**West Yorkshire Police
Kirklees District**

Architectural Liaison Officer

To: Farzana Tabasum Investment & Regeneration Service Kirklees Council Civic Centre 1, Huddersfield, HD1 2EY	Ref: 2016/91573 Date: 12 th December 2017
---	---

**Cellars Clough Mill, Manchester Road, Marsden, Huddersfield
Demolition of existing mill and erection of 55 dwellings with associated parking**

APARTMENTS

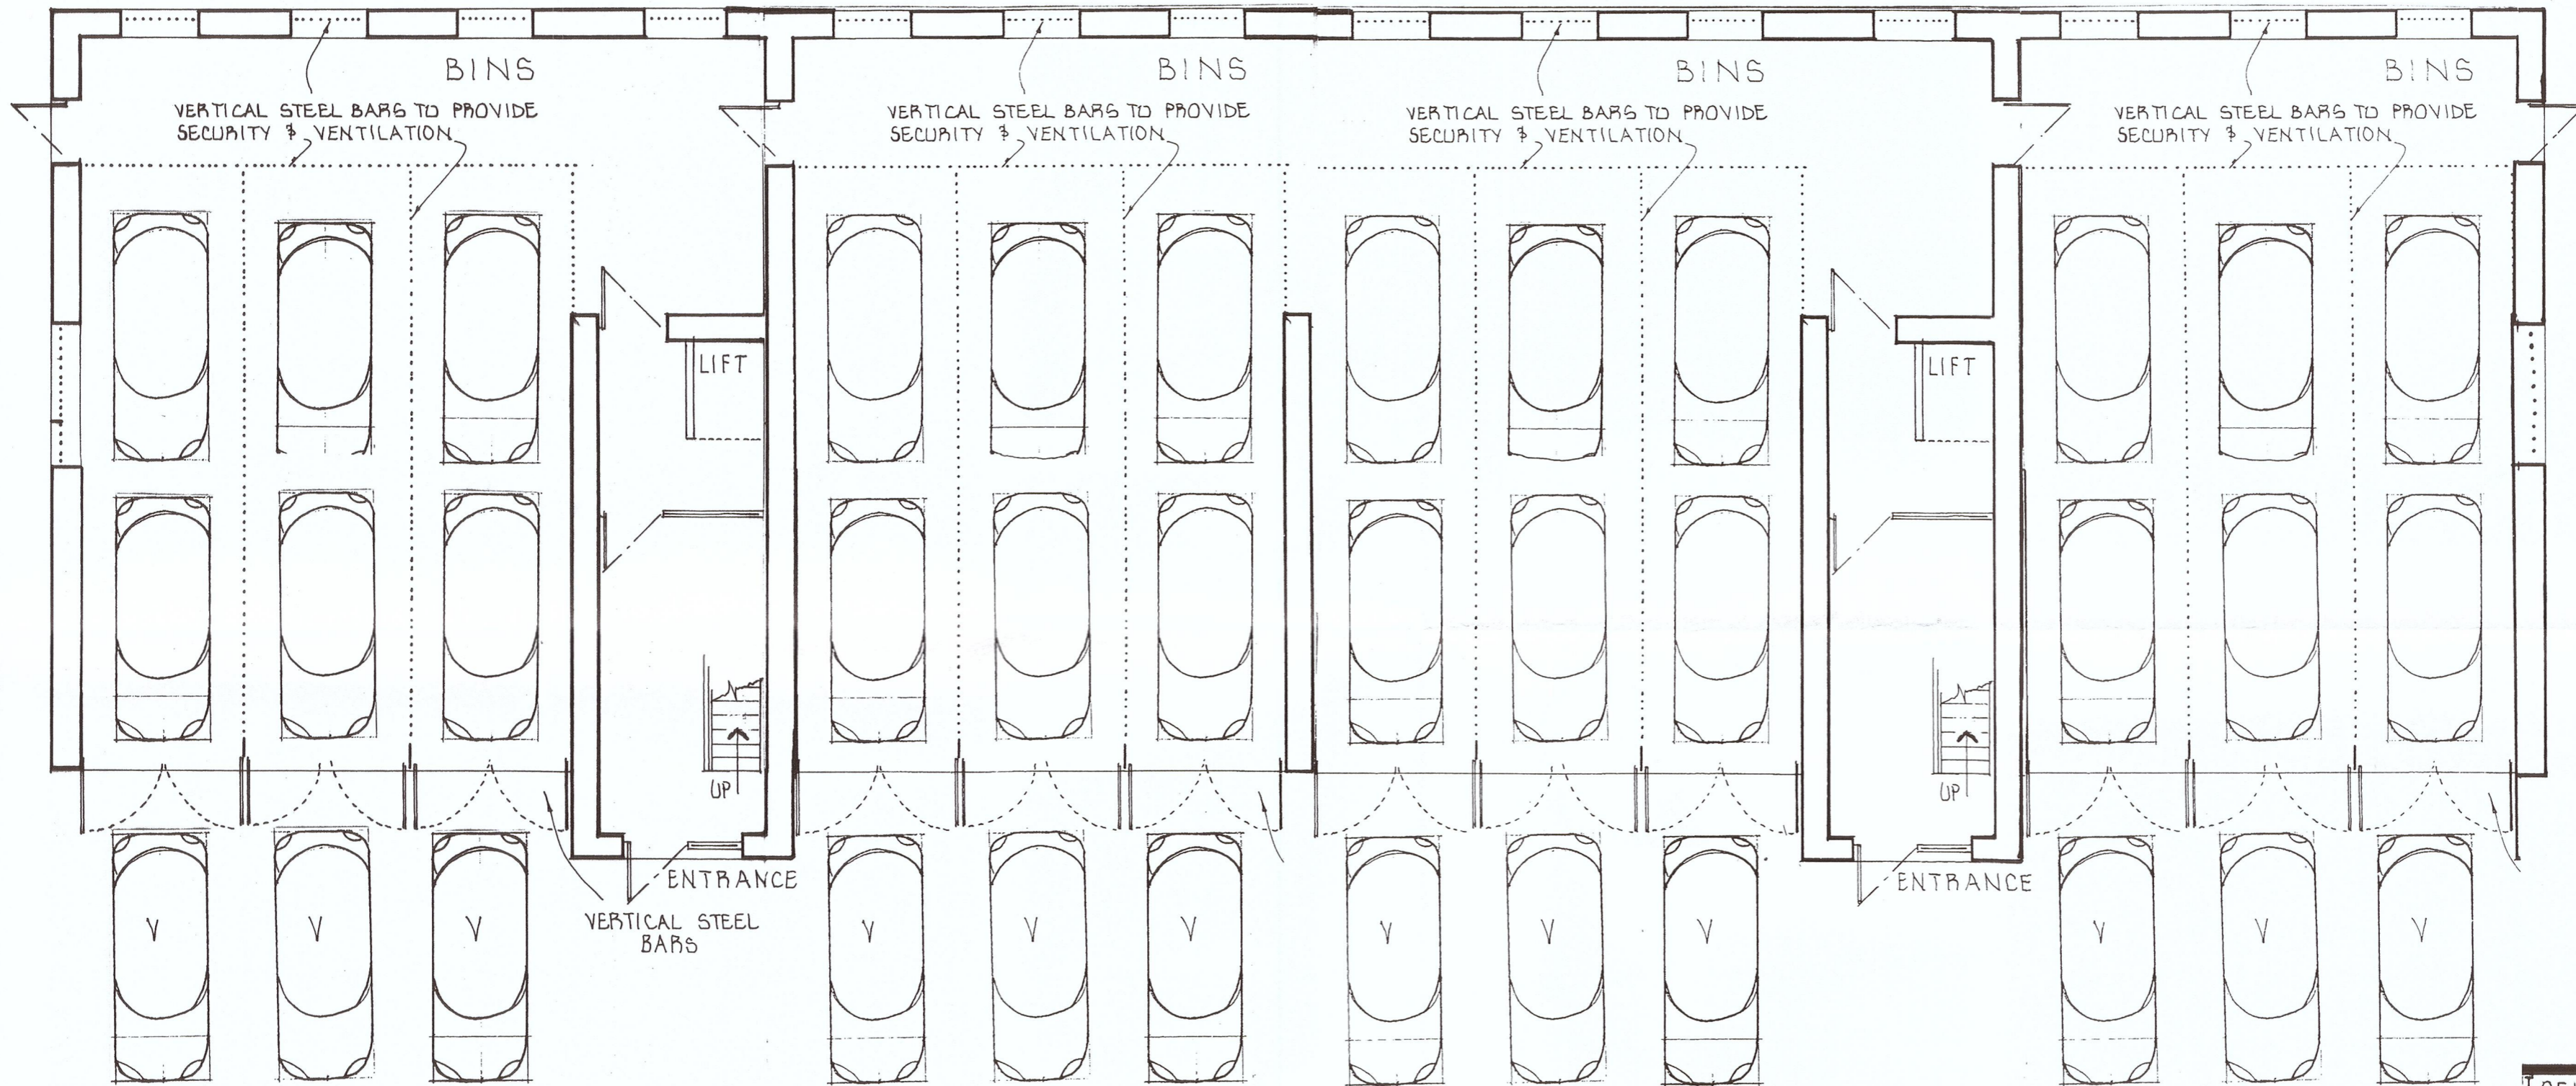
Control of access into the apartment blocks

Multiple occupancy buildings need to have a visitor door entry / access control system.

Any persons gaining unauthorised access into the building could have a great degree of anonymity and the opportunity to have free roam within the corridors, possibly looking to burgle individual flats, or commit other crime / anti-social behaviour.

An access control system providing the following attributes is urged:

- Access to the building via use of a restricted electronic key fob, card or key
- Vandal resistant external door entry system panel with an integral camera
- Remote release of the external entrance door from the individual apartment
- Audio and visual communication between the occupant in the apartment and the visitor at the external door
- Capture (record) images in colour of people using the door entry panel
- Battery back-up facility in case of a power failure in the system
- Consideration of having fob access to individual floor levels should also be made
